**WEST SUSSEX COUNTY COUNCIL
PLANNING SERVICES CONSULTATION**

SUBJECT: Y/44/17/OUT - Outline Planning Application for 70No. residential dwellings including 30% affordable, public open space & associated landscaping. All matters to be reserved apart from Access (access to be achieved via permitted road (reference Y/93/14/OUT). This application is a Departure from the Development plan.

Land at Stakers Farm, North End Road, Yapton, Arundel, West Sussex

PROPOSED SITE PLAN

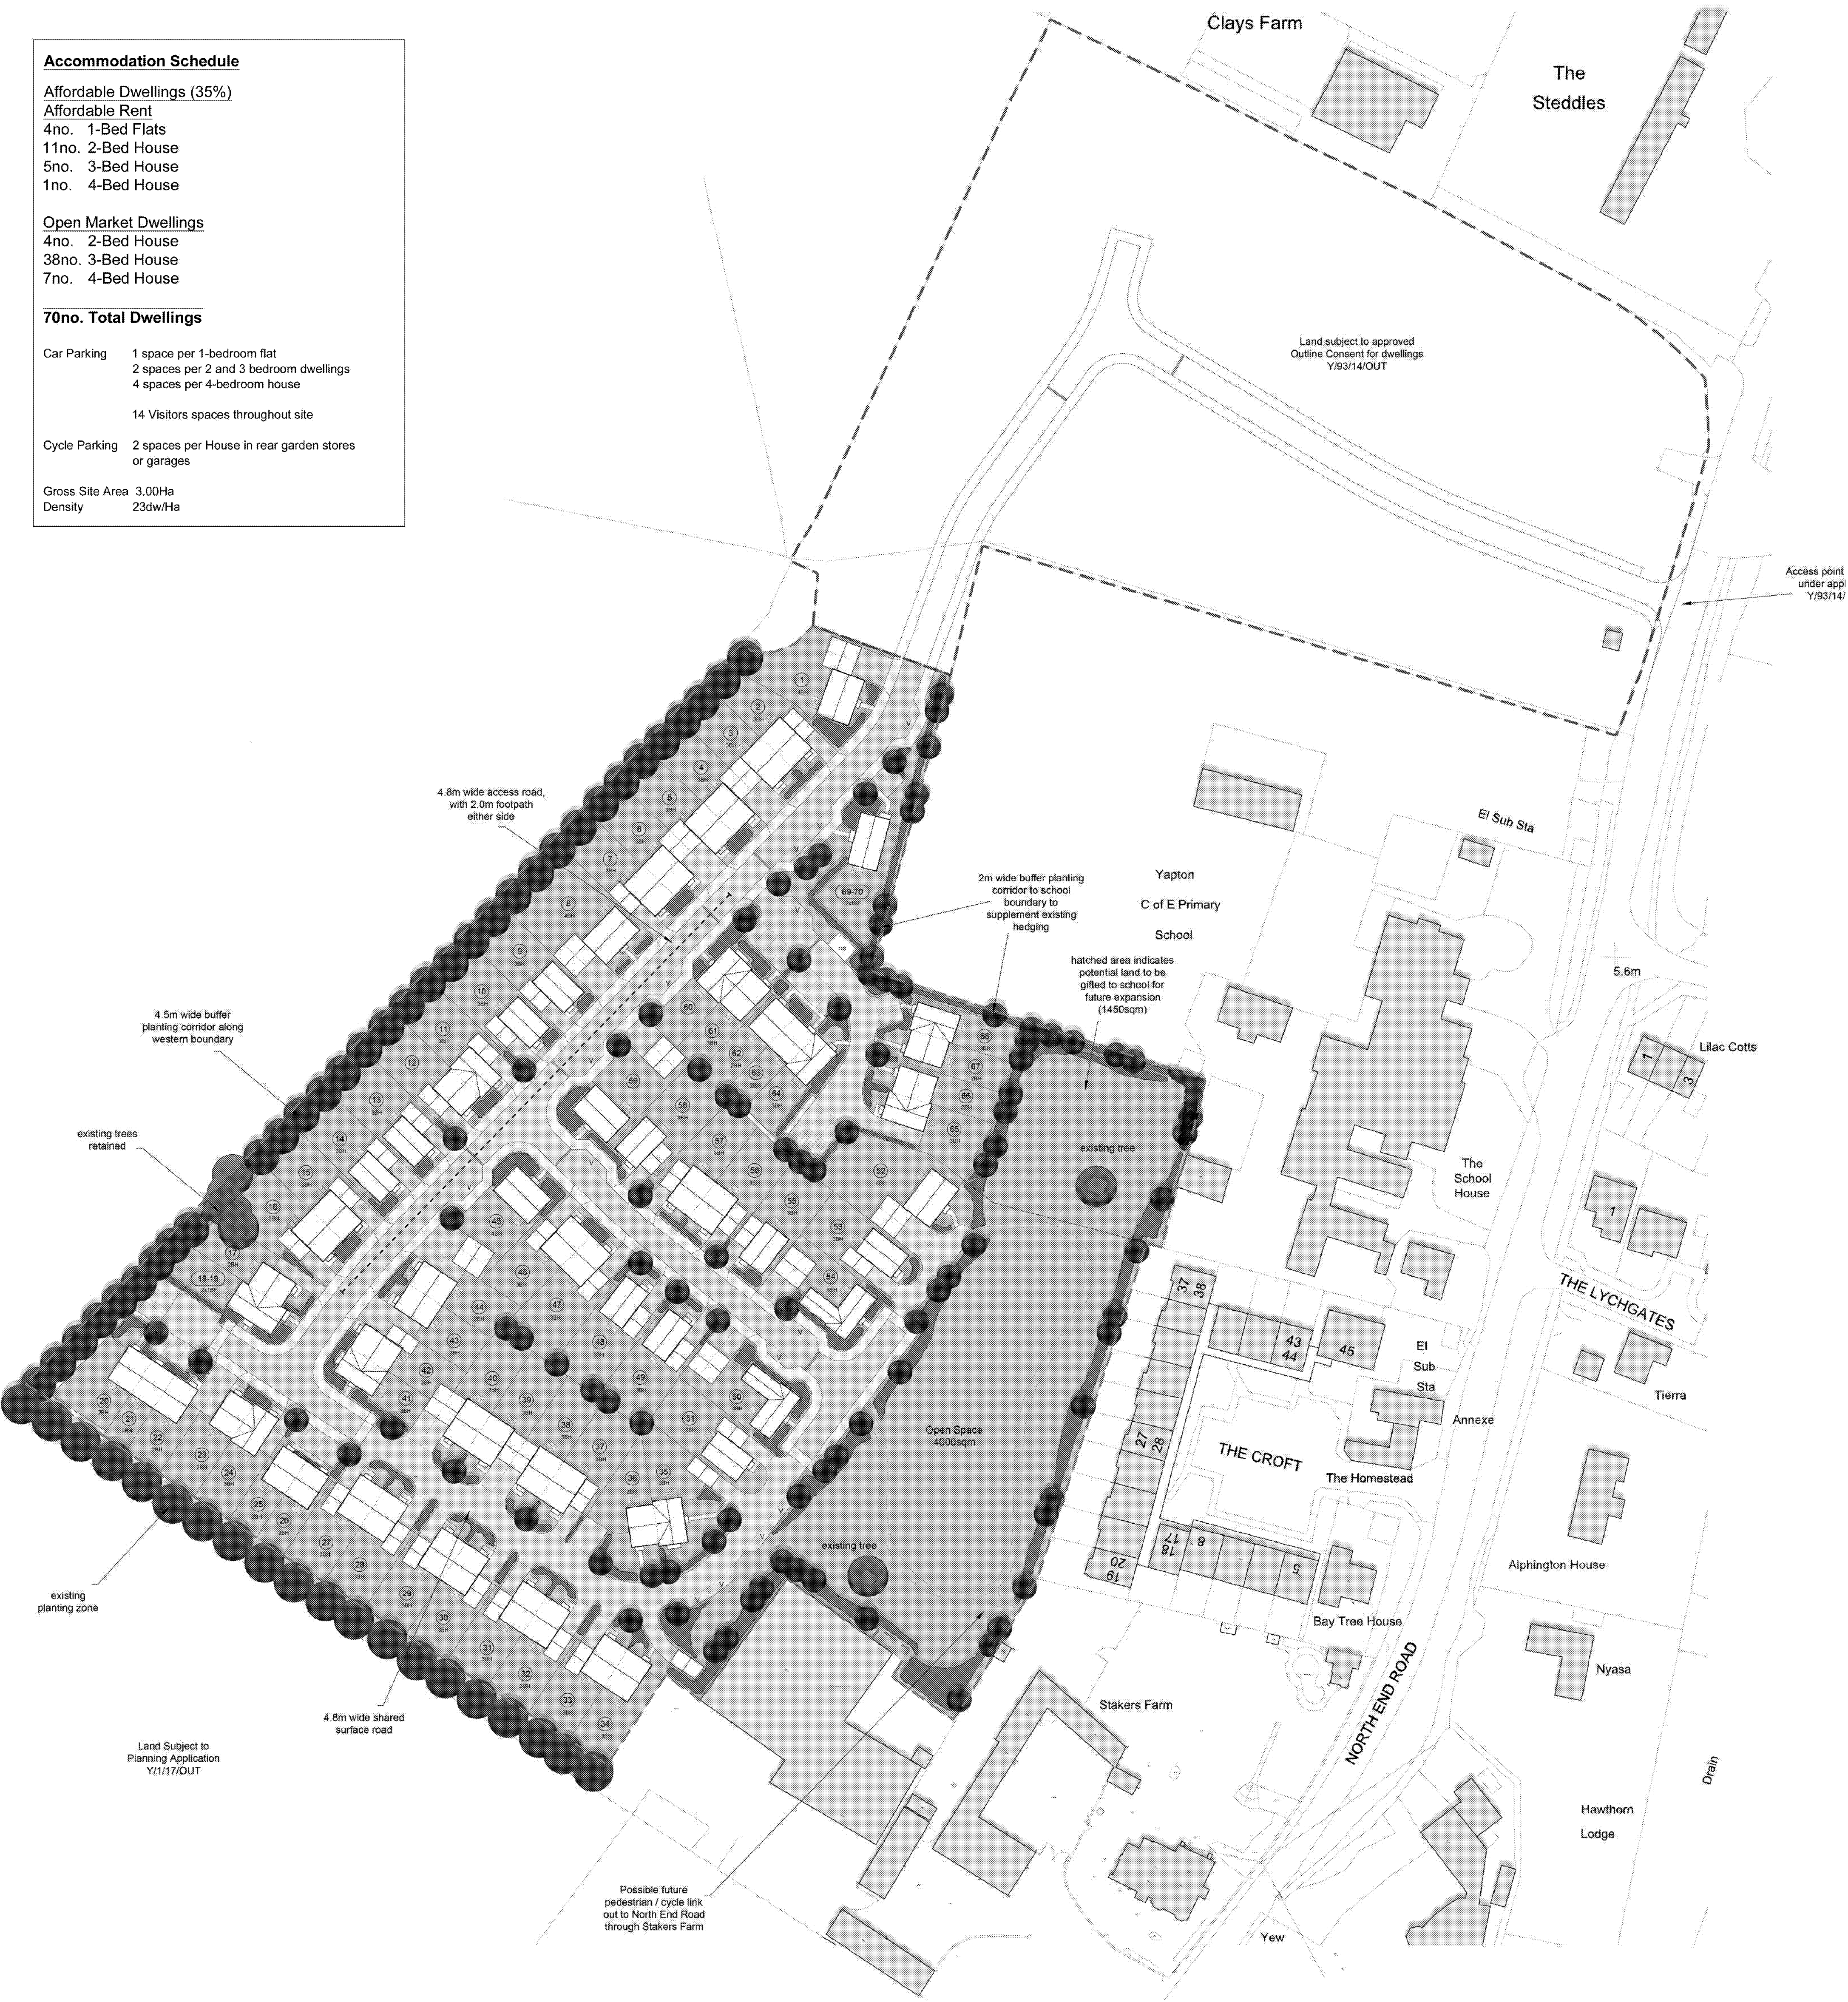
Within our pre app response we raised the issue of options to be explored to introduce a pedestrian connection towards the south of the site through to North End lane, to minimise the distances for residents at the southern end of the development site.

Without either of the above links being in place residents of the southern half of the development could face an additional 450 to 500m being added to each trip to facilities such as the local convenience store, village hall, recreation green and bus stops serving the 700 service.

As such land should be safeguarded within the development to provide a link to both of these potential developments
